Staffordshire County Council

WMI Written Representation

Staffordshire County Council has been in consultation with Oaklands Solar Farm over the proposed scheme during the pre-application period and have identified that the primary matter of interest/concern for Staffordshire relate to the impacts of construction traffic for the development on the Staffordshire road network.

Figure 5: SCENARIO 2A LIKELY CONSTRUCTION VEHICLE ROUTING

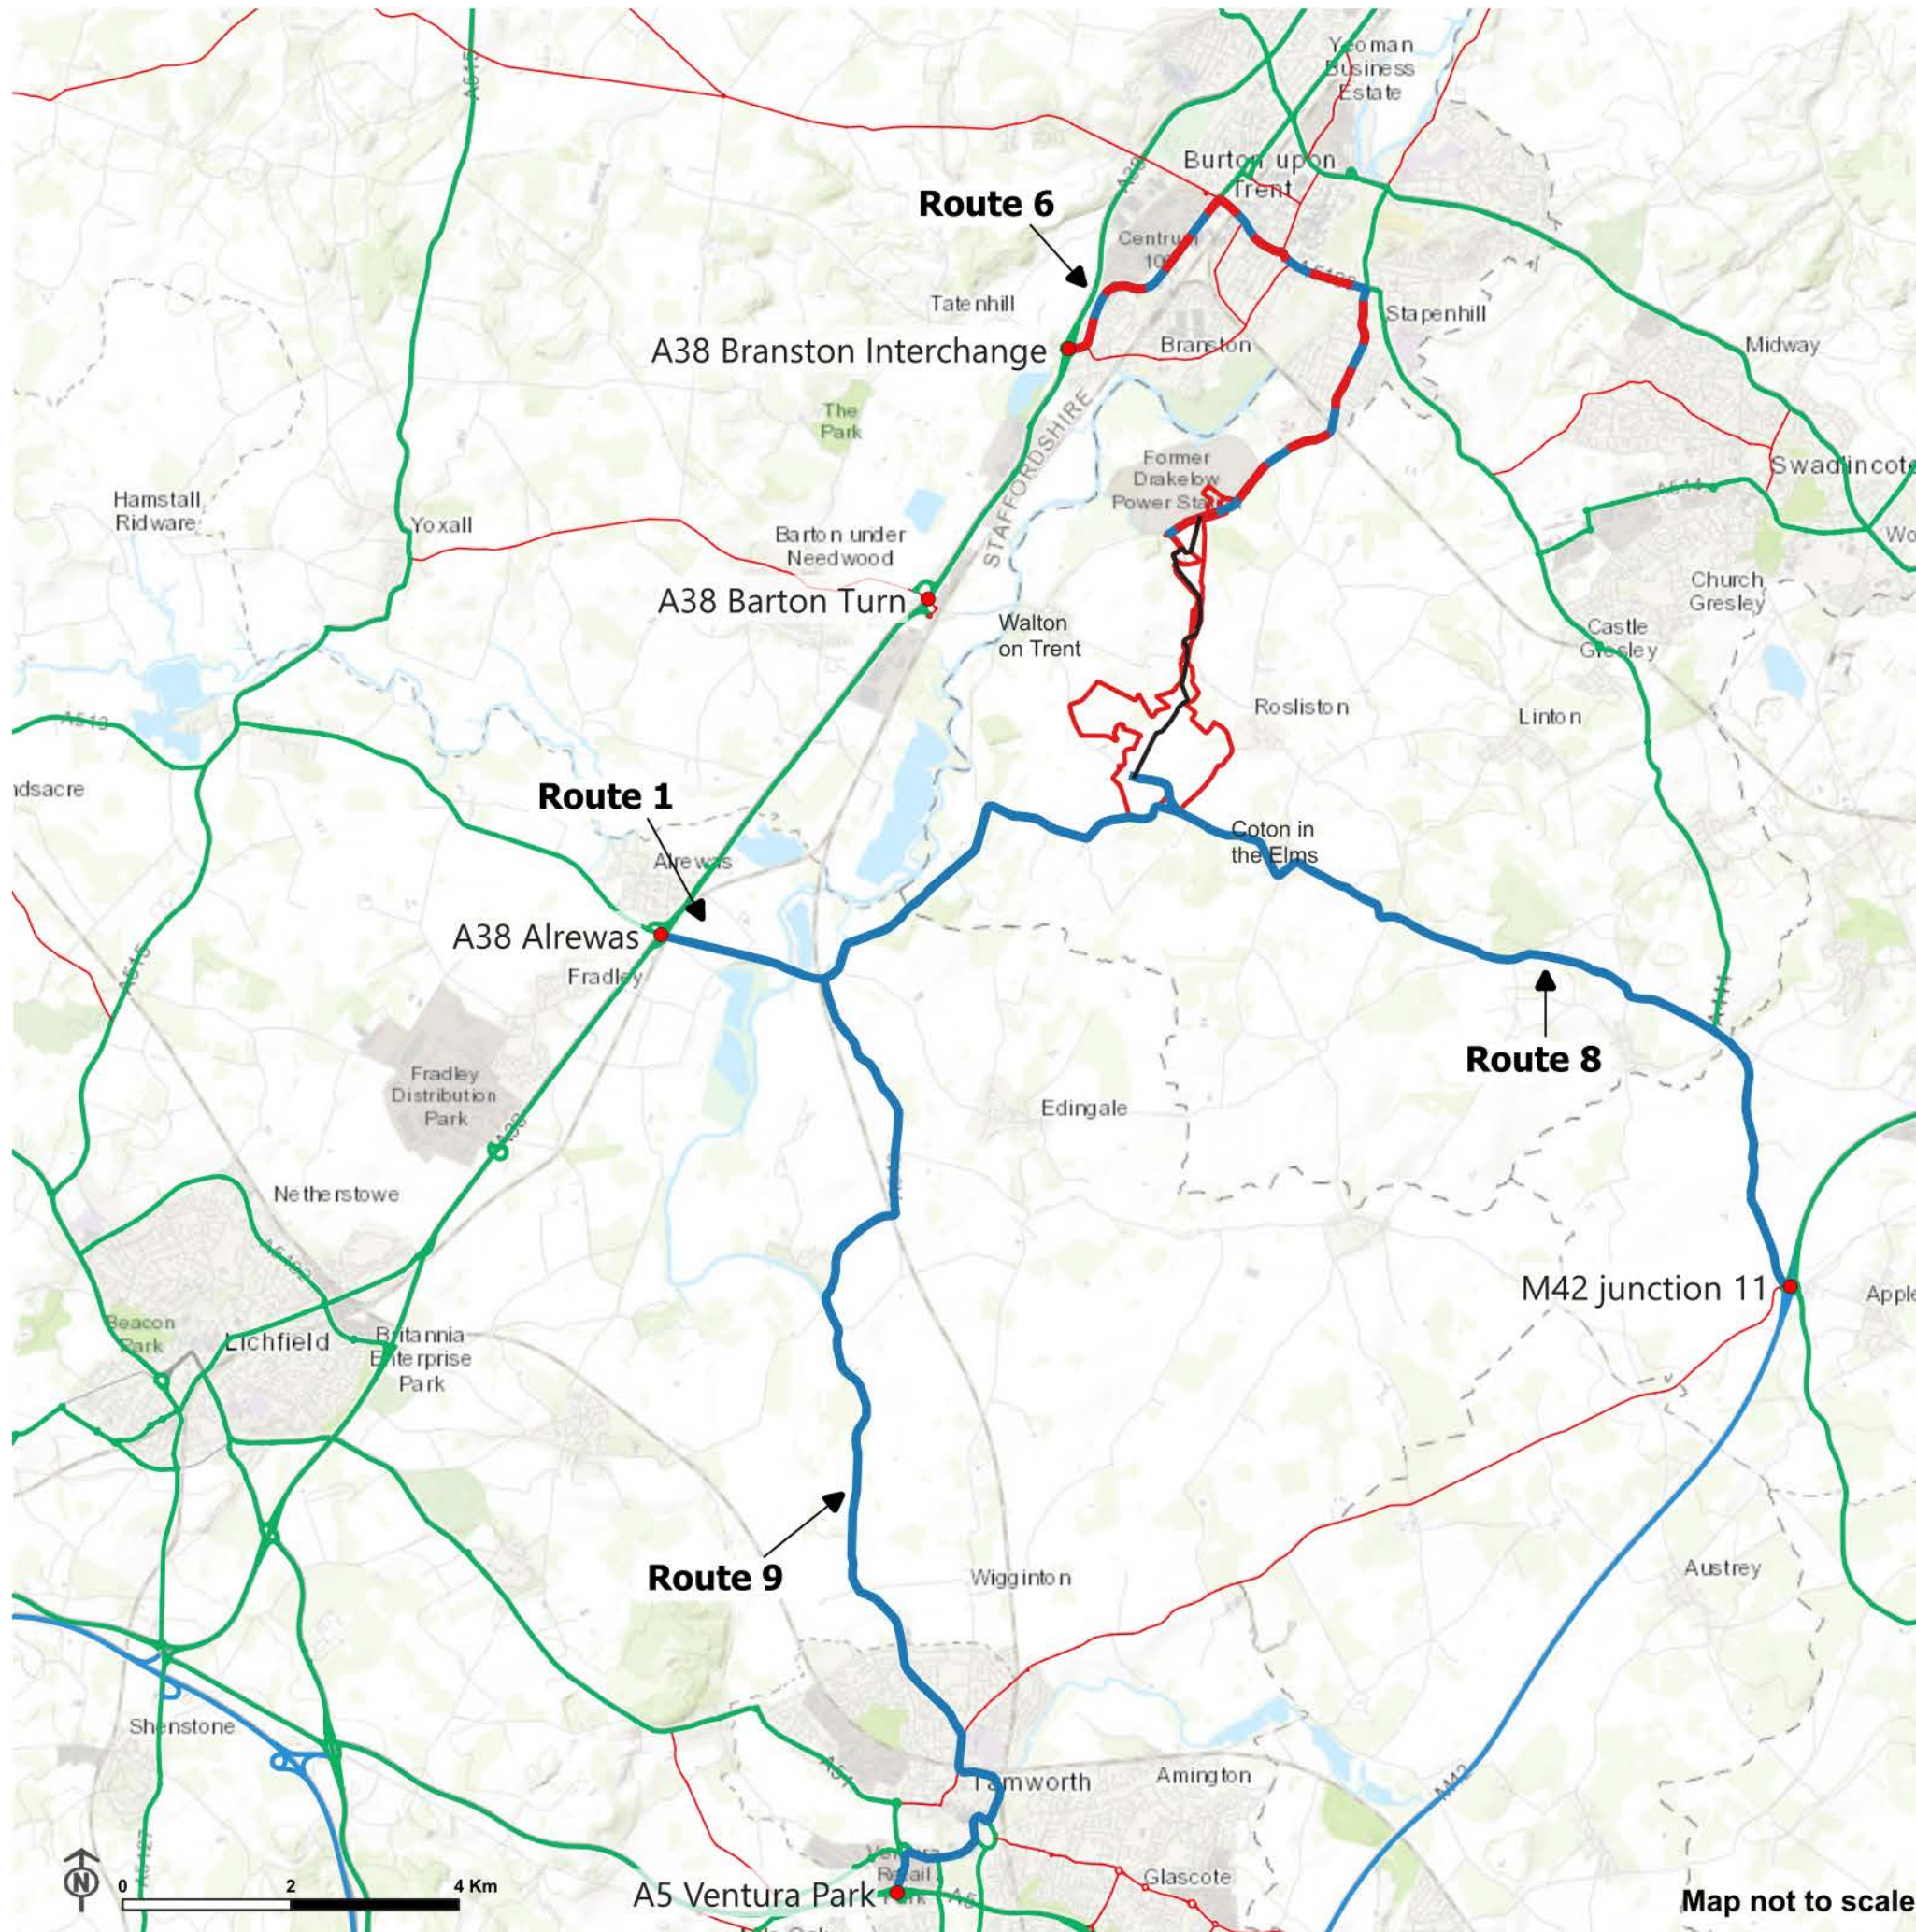
- 2.1. As stated above our preference would be for construction traffic to route via the Walton Bypass. However, recognising the uncertainty around its completion date the developer has had to consider alternatives 2A and 2B.

- 2.2. It is unclear from the assessment undertaken in the Environmental Statement (ES) chapter 10 why routes 2A and 2B could not be used in conjunction with one another to spread the impacts of construction traffic across the network rather than focussing it on a particular route. We would suggest therefore that the Outline Construction Traffic Management Plan (OCTMP) is updated to include provision for a review of construction routes, once the location of materials being transported to site is known, and agreement sought from highway authorities over the construction traffic routes to be used.
